## Fire Marshal Division

**Re: Neills Creek Baptist Church**  
**4200 Neills Creek Rd.**  
**Angier, NC 27501**

**Application Number BCOM2004-0003**

DOOR ELEVATIONS
1/4" = 1'-0"

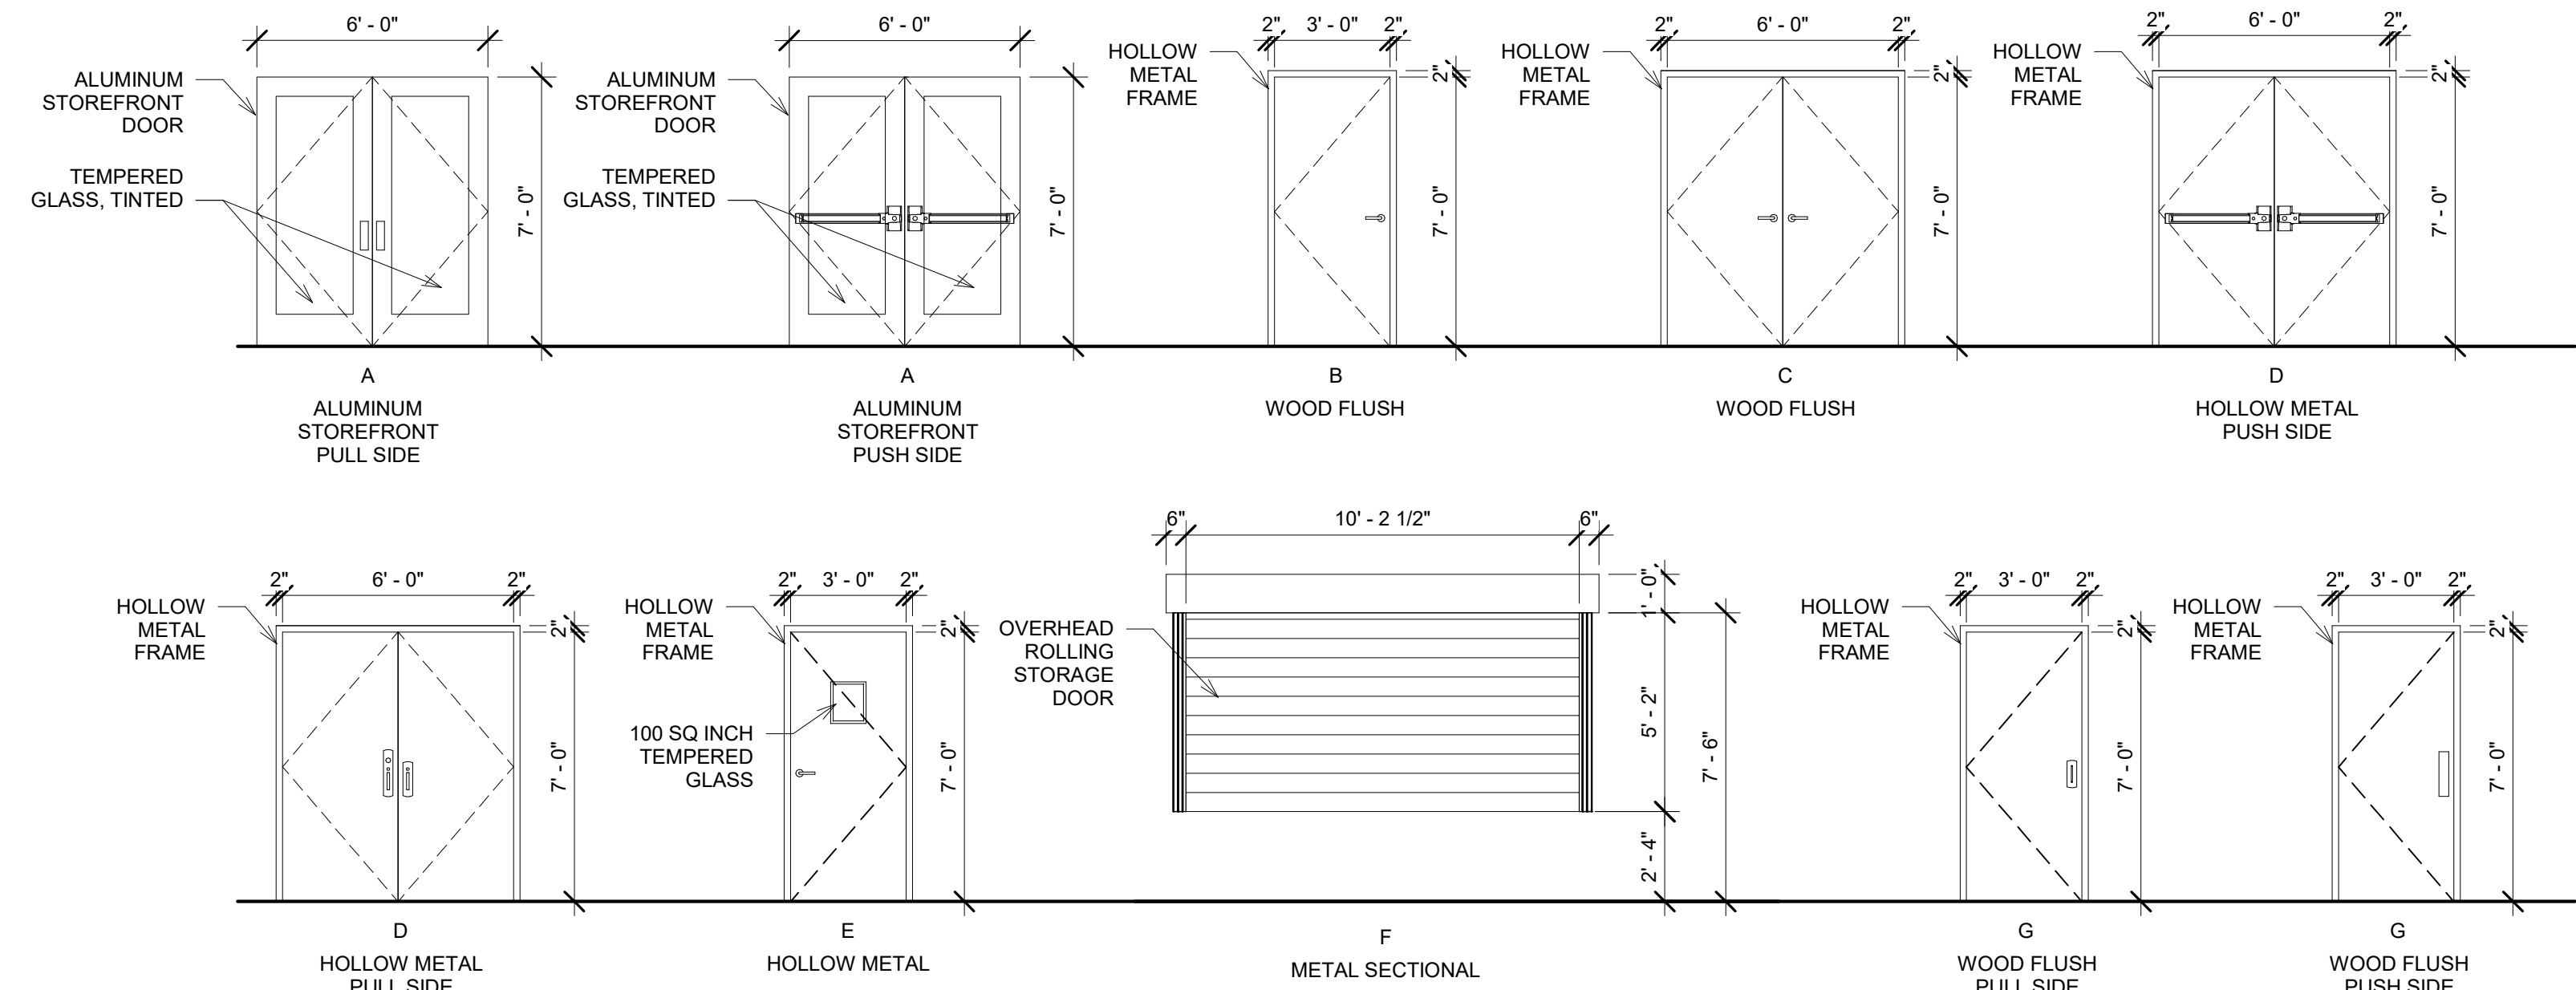
- UL 305 listed panic hardware is required on exit doors serving a room/space with an occupant load >50, also indicated on Building code summary. Panic hardware is not included on door schedule sheet B8 of Drawings.
